Your Ref: OWPC16254
Our Ref: FG/162/17/PL 10-10-2017
Please ask for:
Mrs A Gardner

Demolition of existing detached garage & erection of 1 No. dwelling.
1 Upper West Drive Ferring

Thank you for your internet representation made on 12th November 2017 which has been recorded as '**an objection**' with the comments as follows:

EXISTING SITE PLAN 1:100

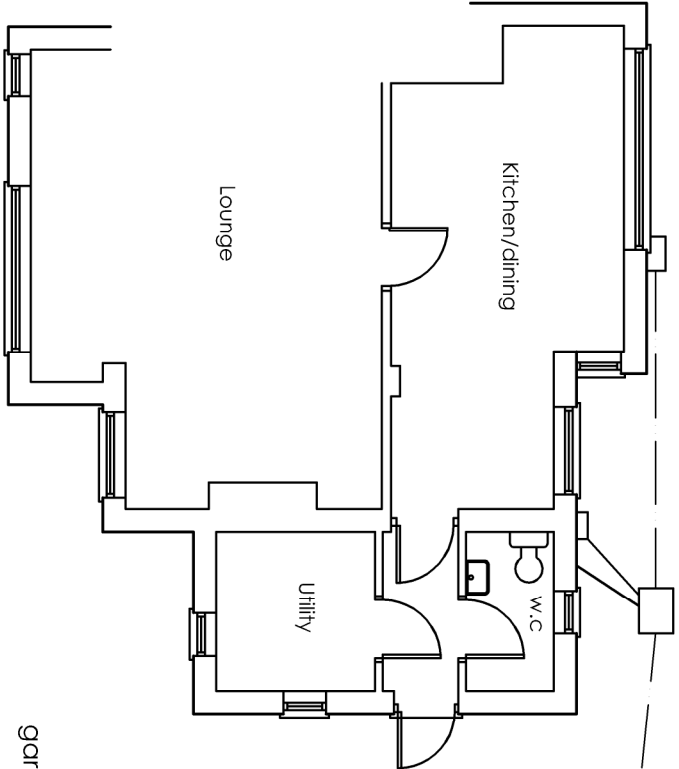
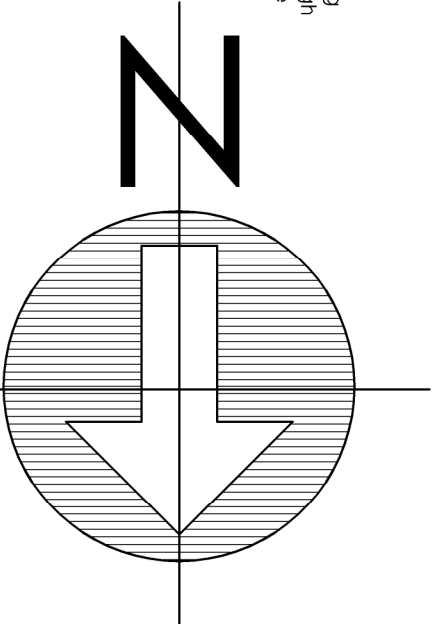
There would be very limited space on the side boundaries to the north and south, plus the rear garden would be practically unuseable.

It would be far too close to the existing large and mature Sycamore tree, currently protected by a TPO, and this tree is likely to be damaged in any building work despite the assurances of the applicant's agent, as well as coming into conflict with the structure of any new building on the site, which would then put the future of the tree at risk. This is exactly what happened to a mature tree just north of the site, which was felled just a couple of years ago.

PROPOSED GROUND FLOOR PLAN 1:100

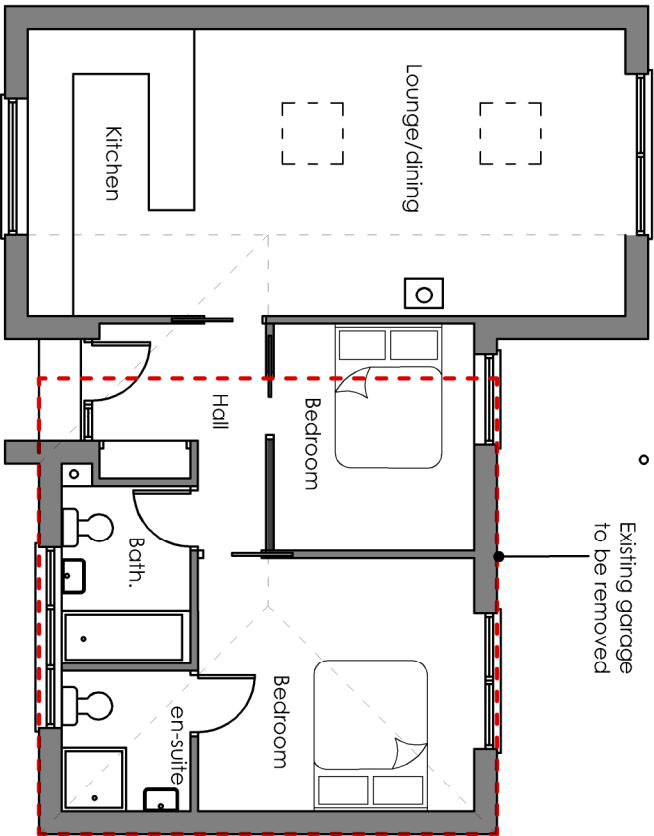
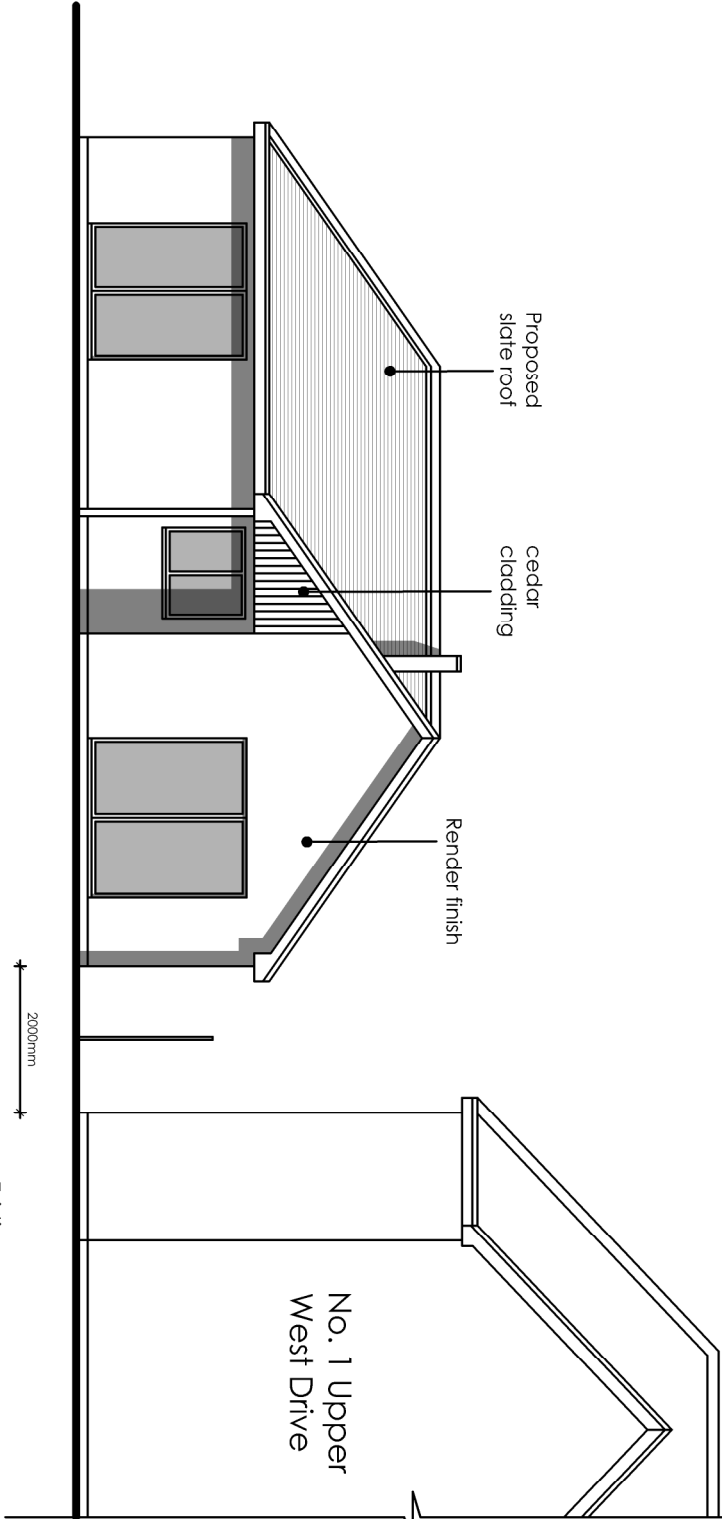
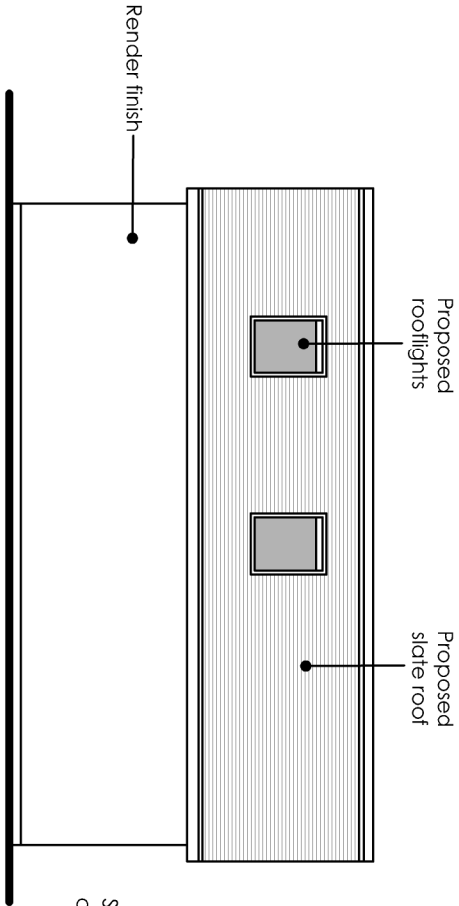
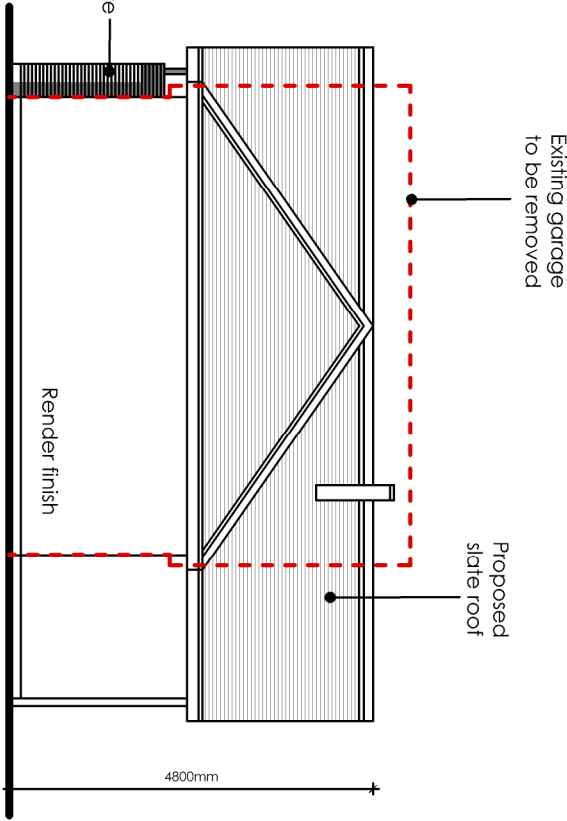
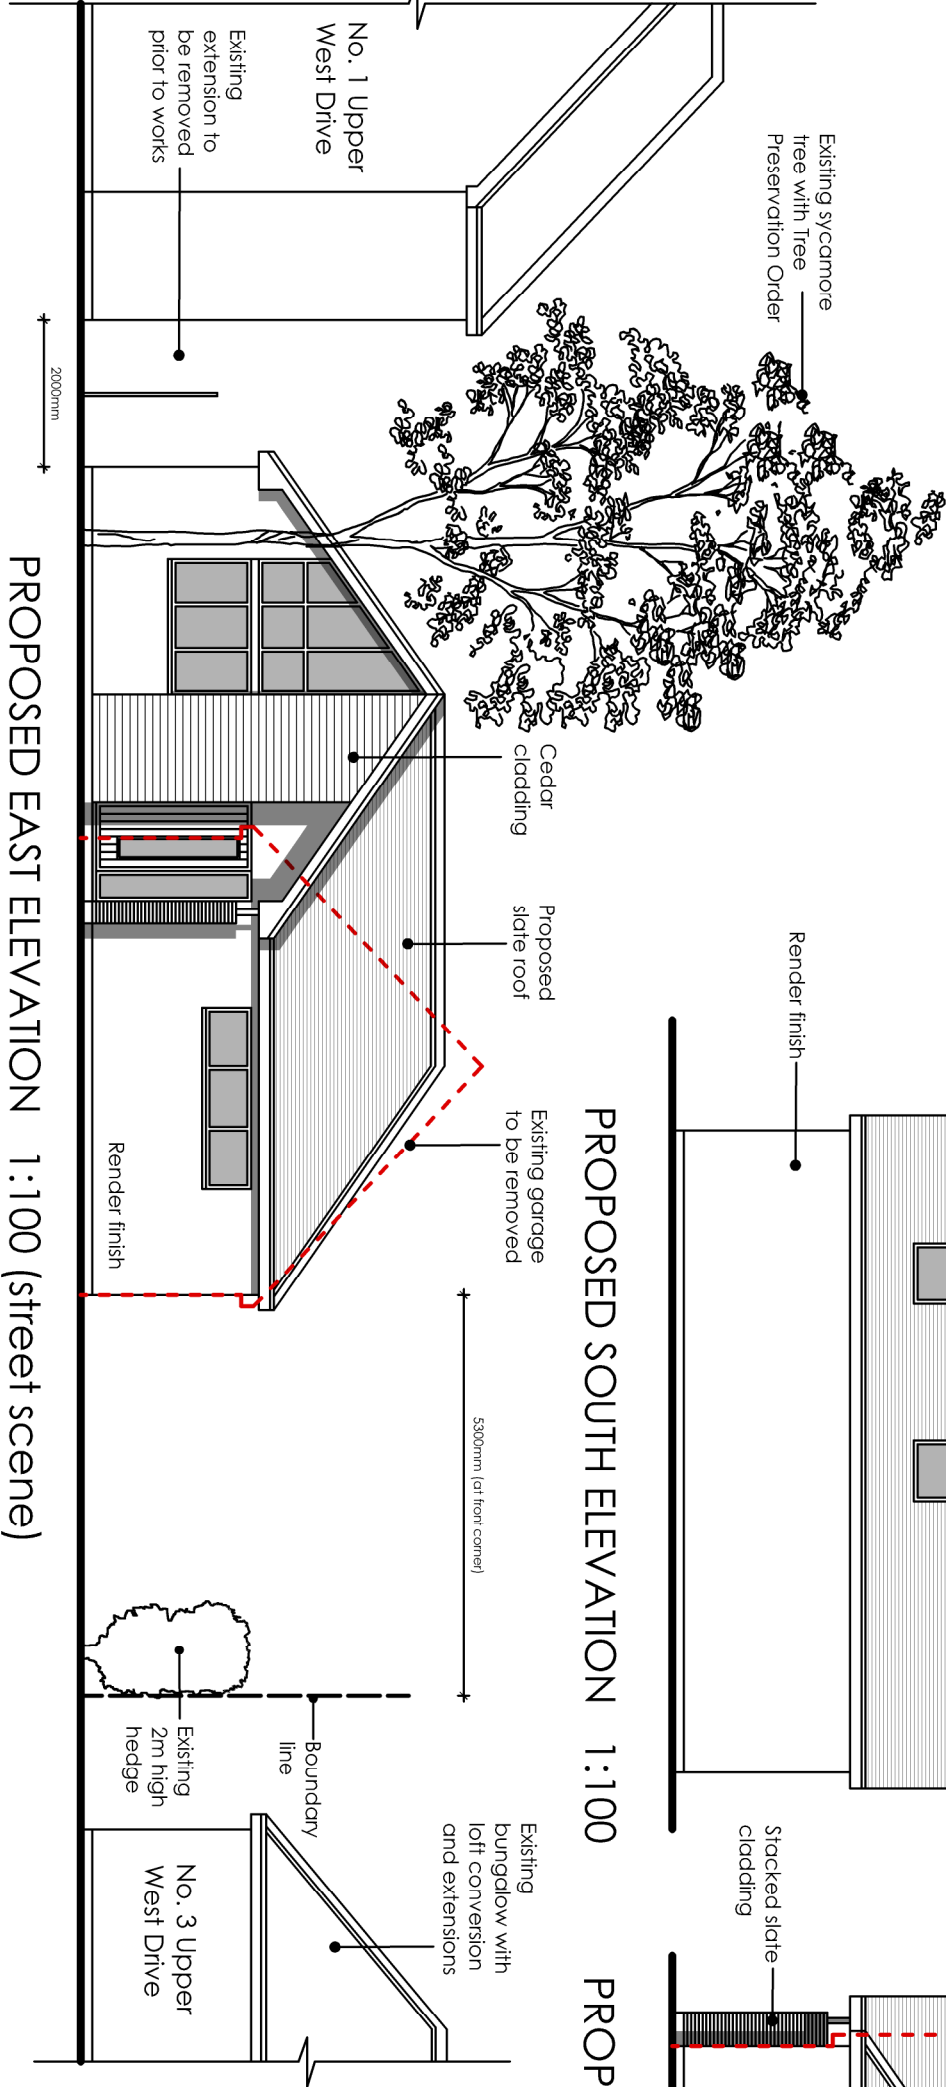
I consider this application to be a clear cut case of overdevelopment of a very cramped site, which requires demolition of part of the existing house just to fit it in. It is the sort of infilling proposal that the village of Ferring doesn't need.

In conclusion, this is an unnecessary application squeezing another small dwelling into a very small and impractical site, and as such it should be refused.
